<b>Application Ref:</b>	3/2021/0099	 <b>Ribble Valley Borough Council</b> <a href="http://www.ribblevalley.gov.uk">www.ribblevalley.gov.uk</a>
<b>Date Inspected:</b>	26.01.21	
<b>Officer:</b>	<b>LE</b>	
<b>DELEGATED ITEM FILE REPORT:</b>		<b>Decision</b> <b>APPROVE</b>

<b>Development Description:</b>	Proposed construction of single storey side extension to the south west elevation of Spring Cottage.
<b>Site Address/Location:</b>	Spring Cottage Sawley Old Brow Sawley BB7 4LF

**PROPOSED
ELEVATIONS**

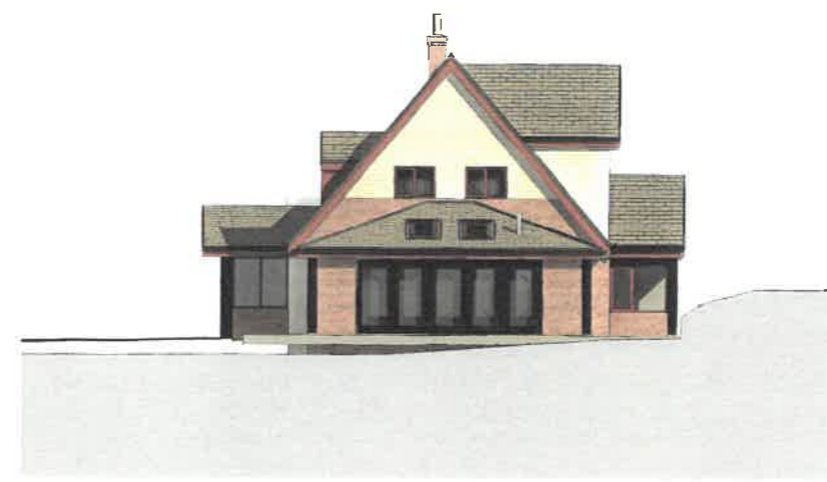
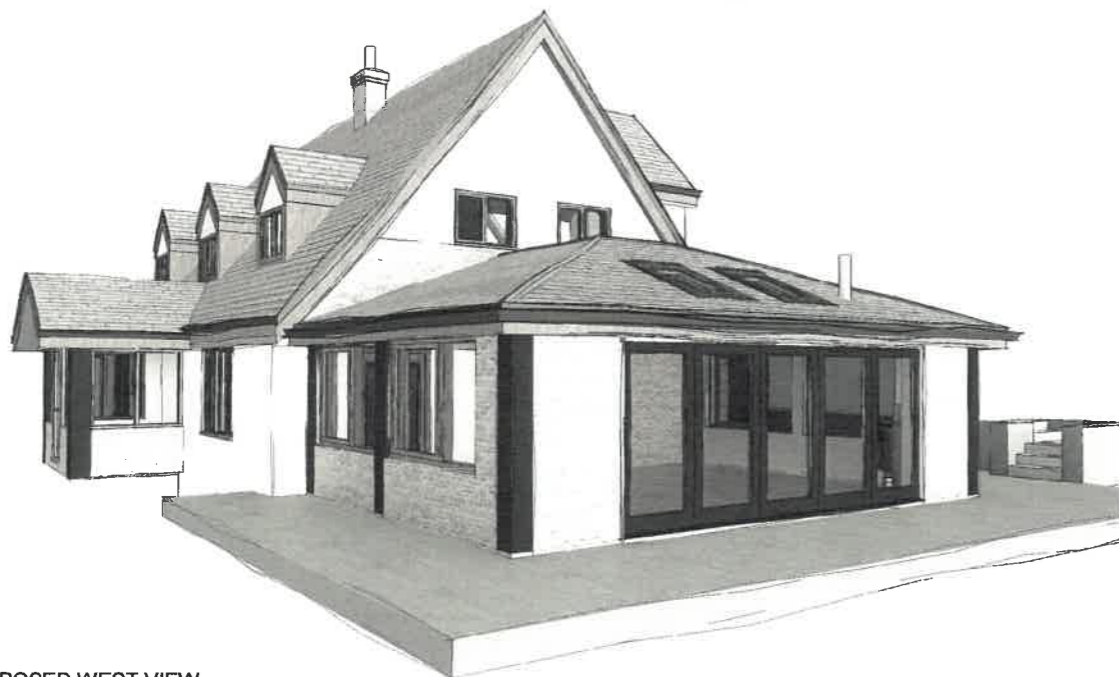
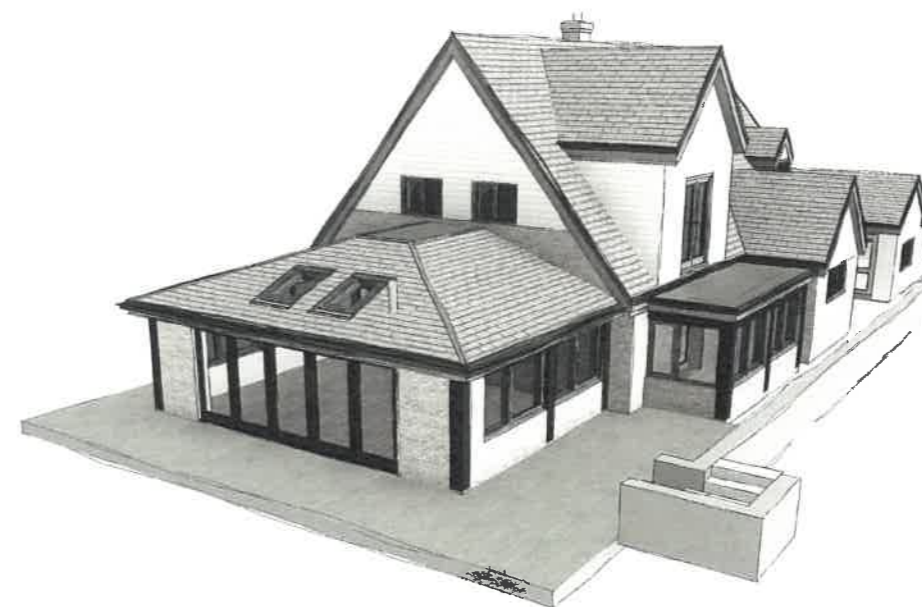
The proposed extension will have a hipped roof and be subservient to the host property. The plans indicate that it will be constructed using similar materials. The plot is generous and the extension will not be over dominant in the street scene.

The dwelling is relatively modern and is not identified as a building of townscape merit. The extension is sympathetic in terms of scale, design and choice of materials. It is considered that the character and appearance of the conservation area will be maintained. The proposal accords with core strategy policies and the NPPF and the duties under the Planning (Listed Buildings and Conservation Areas) Act are satisfied.

**PROPOSED SITE  
PLAN**

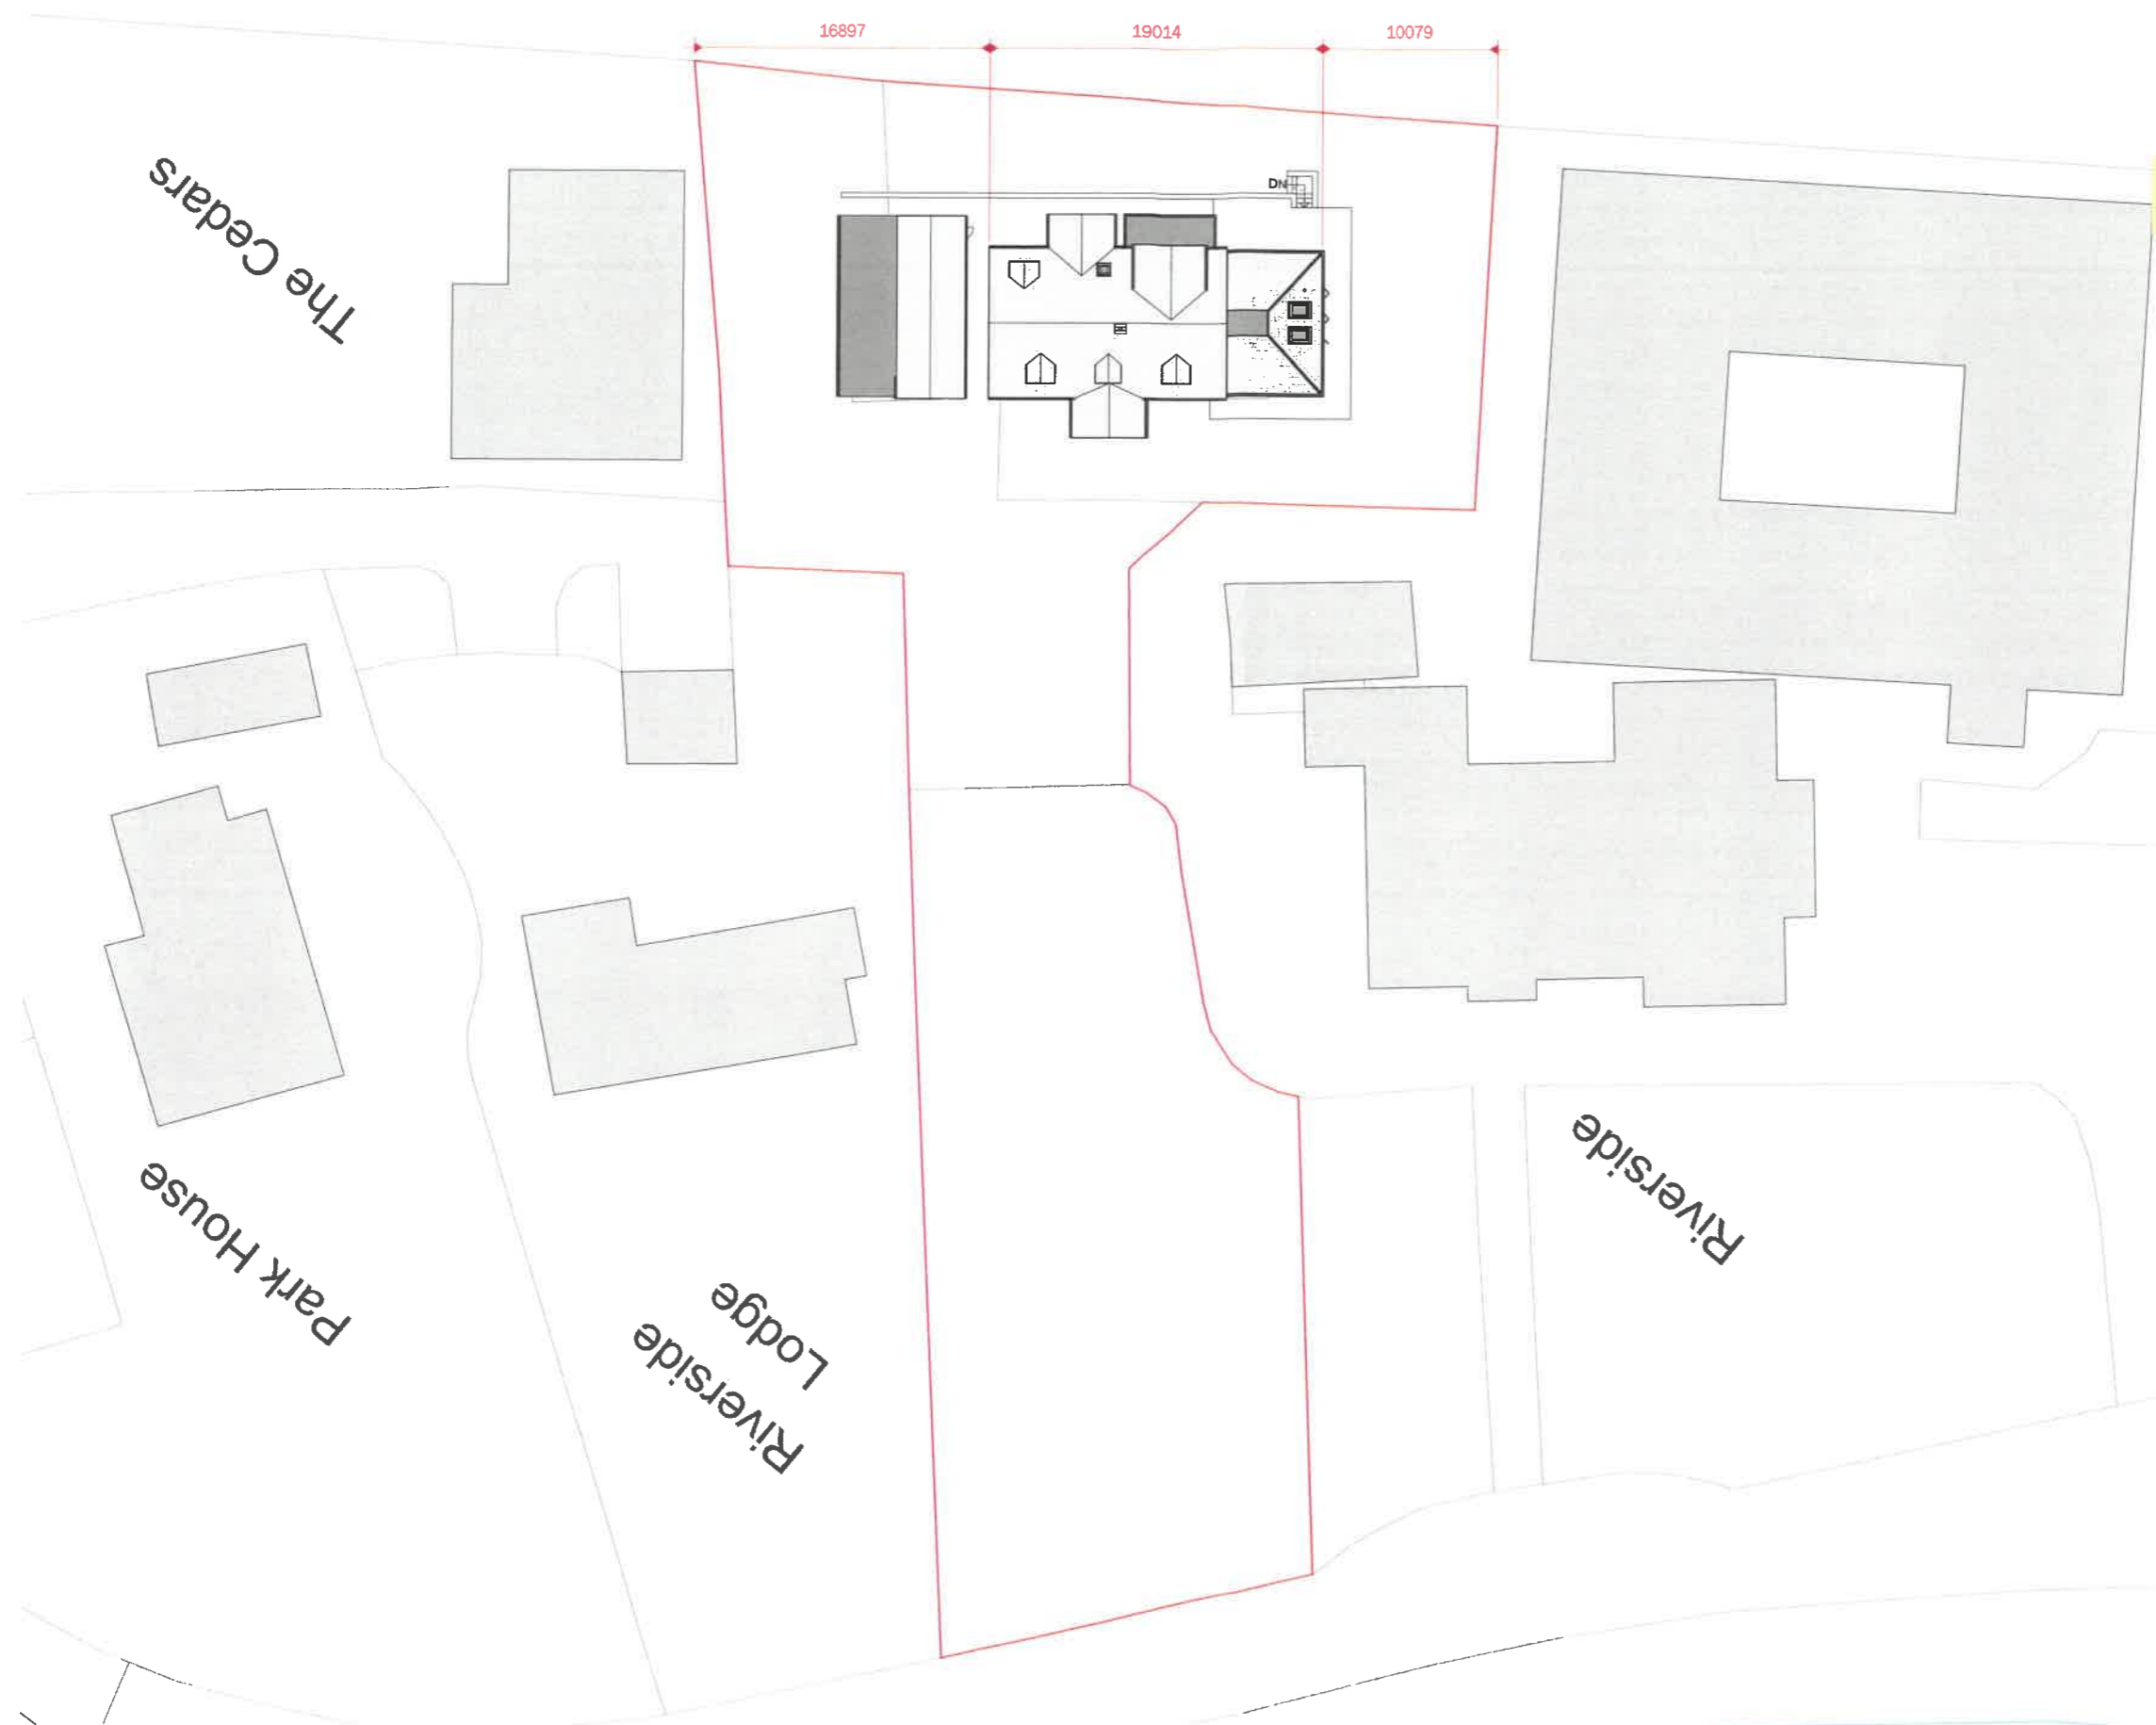
The site lies adjacent to Ribble Valley Care Home which is the only near neighbour that would be affected by the proposal. The extension will be over 10 metres from the side boundary and the windows are at ground floor level so there is no envisaged overshadowing of neighbouring properties or loss of privacy as a result of the proposal.

It is noted from the conservation area map that there are important trees to the rear boundary which should not be affected by this proposal. It is also noted that there is a current application for tree works under consideration. A precautionary condition will be imposed to require these trees to be protected during development if they are likely to be affected.
